KITTITAS COUNTY

MEMORANDUM

TO: All Staff
FROM: Public Works Plan Review Team
DATE: March 14th, 2024
SUBJECT: SE-24-00010 Mallula-Dykes Public Works Comments

CONCEPTUAL SITE PLAN

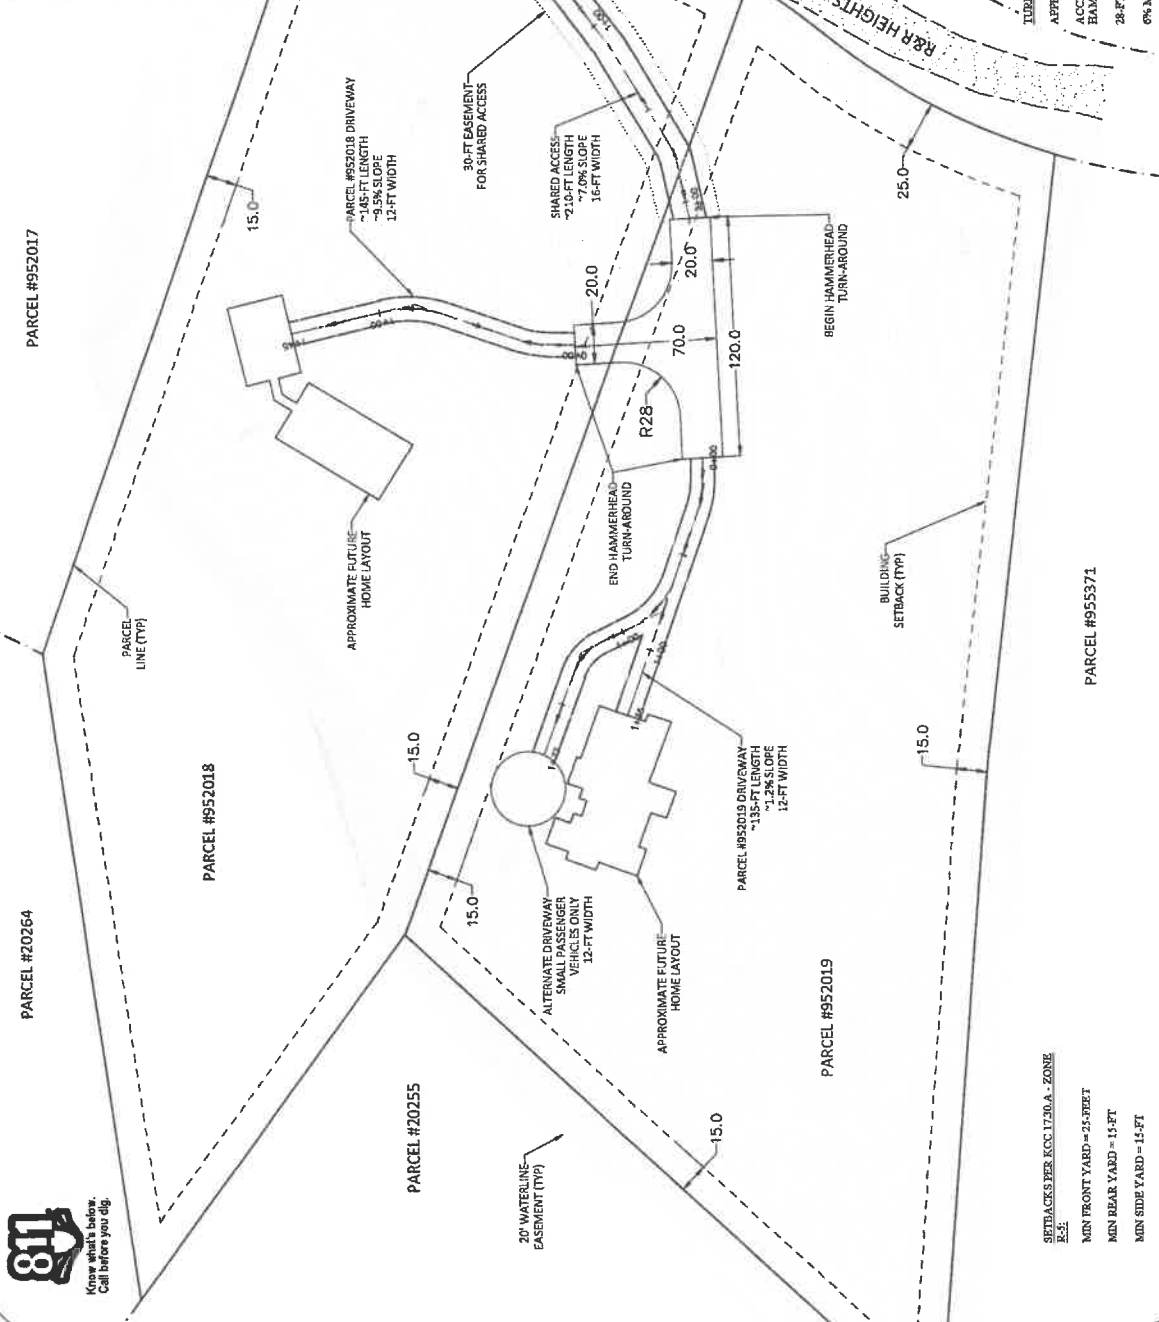
<p>ACCESS</p>	<ol style="list-style-type: none"> 1. Parcel 952018 has an issued access/address permit AA-23-00090 and parcel 952019 has an issued access/address permit AA-23-00087. A new site plan may be required if the project design has changed for the plans submitted with the access permit. Refer to Chapter 12 of the Kittitas County Code for access requirements. 2. Maintenance of driveway approaches shall be the responsibility of the owner whose property they serve. The County will not maintain accesses. 3. The access shall have a minimum width of 12' if the length of the driveway is less than 150', or 16' if the length of the driveway is more than 150'. 4. Accesses longer than 150' in length are required to provide a Fire Apparatus Road Turnaround meeting the requirements of Appendix D in the International Fire Code. 5. In addition to the above-mentioned conditions, all applicable Kittitas County Road Standards apply to this proposal. Access is not guaranteed to any existing or created parcels on this application. (TM)
